Arun District Conservation Area Advisory Panel
c/o Civic Centre

Application No: AB/12/21/PL

Site Address: Old Bank House 3 High Street Arundel BN18 9AD

Description of works: Internal & external alterations to existing building to facilitate the change of use to a residential dwelling granted under AB/122/20/PD to include demolition of single storey rear extension, removal of rear external chimney, change existing window to front elevation to entrance door & new french doors to rear elevation. This application affects the setting of a listed building, affects the character & appearance of the Arundel Conservation area & is in CIL Zone 2 (Zero Rated) as other development.

Project:-			
Old Bank House 3 High Street Arundel West Sussex			
Title:-			
Proposed Site Plan			
Client:-			
Moor Construction Ltd			
Scale:-			
1:100 (@A1)			
Drawn By:-	PJD	Checked By:-	PJD
Date:-	12/02/21	Date:-	12/02/21
Job.No:-	200042	Drg.No:-	22
		Rev:-	A

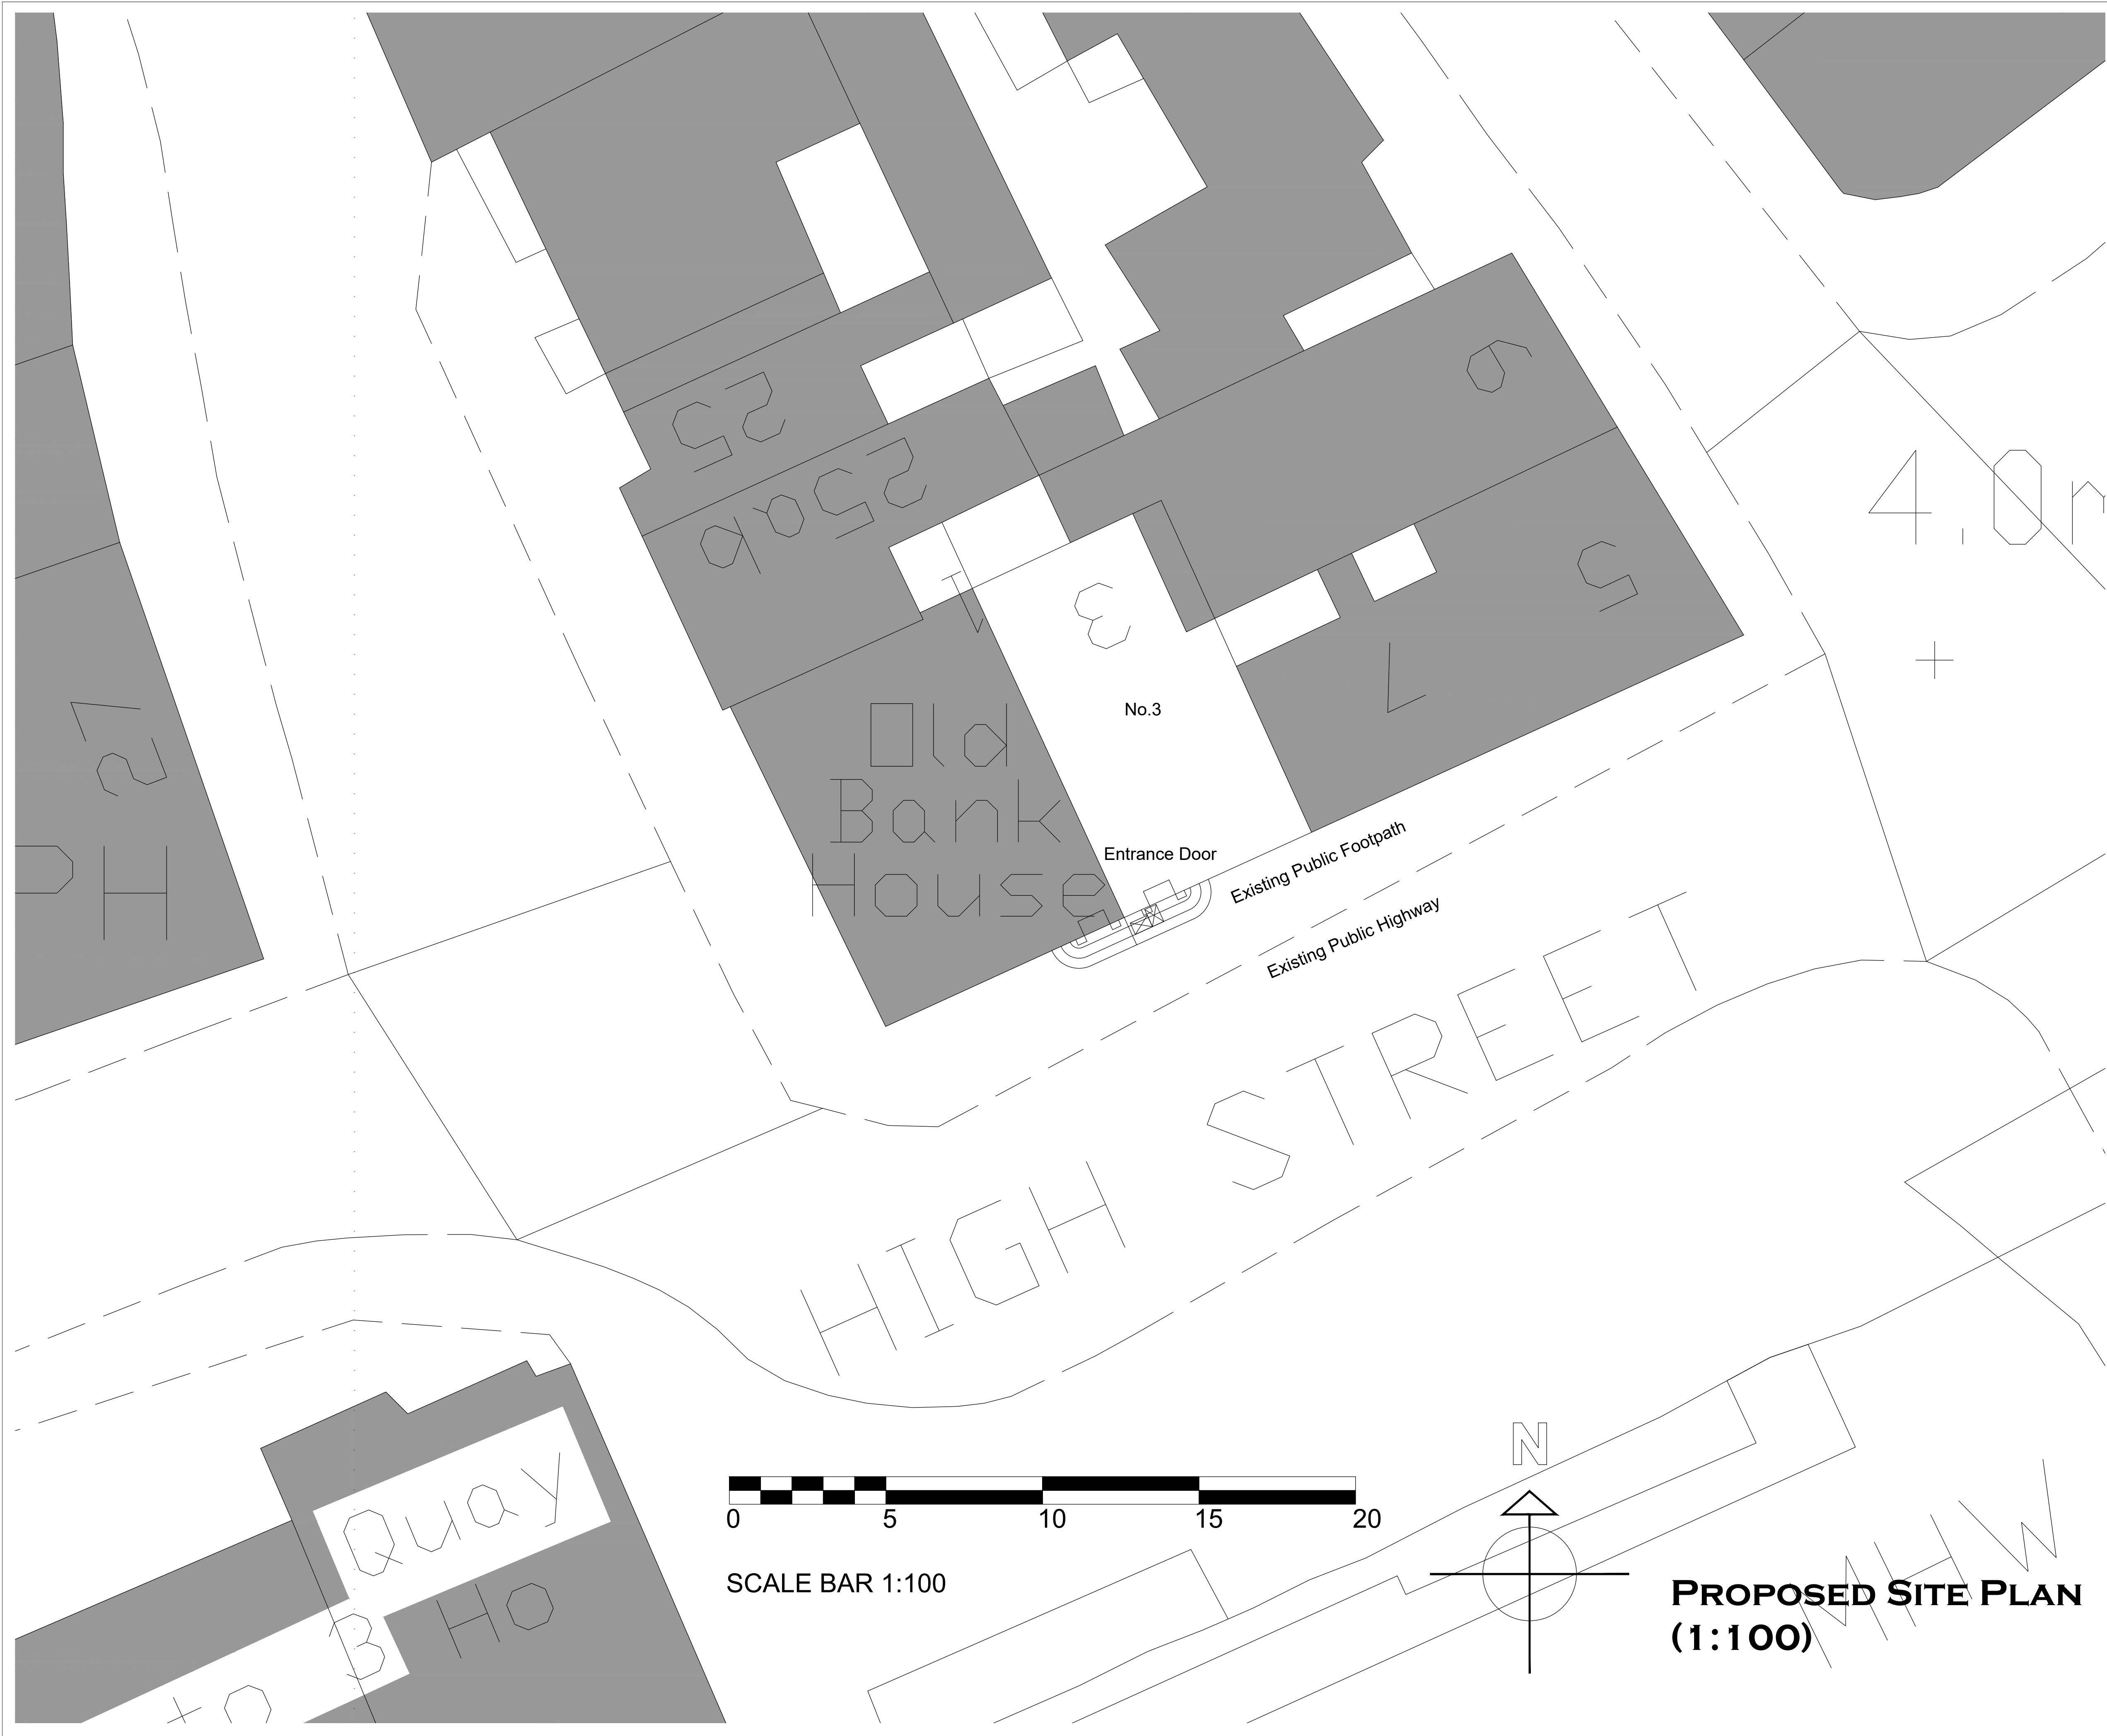
The Panel is concerned that insufficient information is provided concerning the formation of the new door entrance on the road frontage. Both the description of the application and the Design and Access/Heritage Statement simply refer to a new door but there is no reference to the proposed new doorcase and steps which are shown on the (proposed) south elevation plan. The ground floor plans do not show the outline of the new doorcase and steps implied on the elevational plan. They show a new door located almost flush with the front wall and not deeply recessed which would be the case if it is intended to match the doorcase details on the adjoining listed building.

Neither the plans nor the supporting statements address how any new steps which will undoubtedly be required in order to access any new doorway can be provided with the existence of the two manholes

adjoining the front of the building.

In the view of the Panel, given the sensitive historic environment and townscape, the new door entrance should incorporate a painted timber doorcase which precisely matches in design, dimensions, profile and detailing that of the adjacent listed building. New steps should also match in design, materials and dimensions those of the adjacent building. Detailed plans should accompany the application.
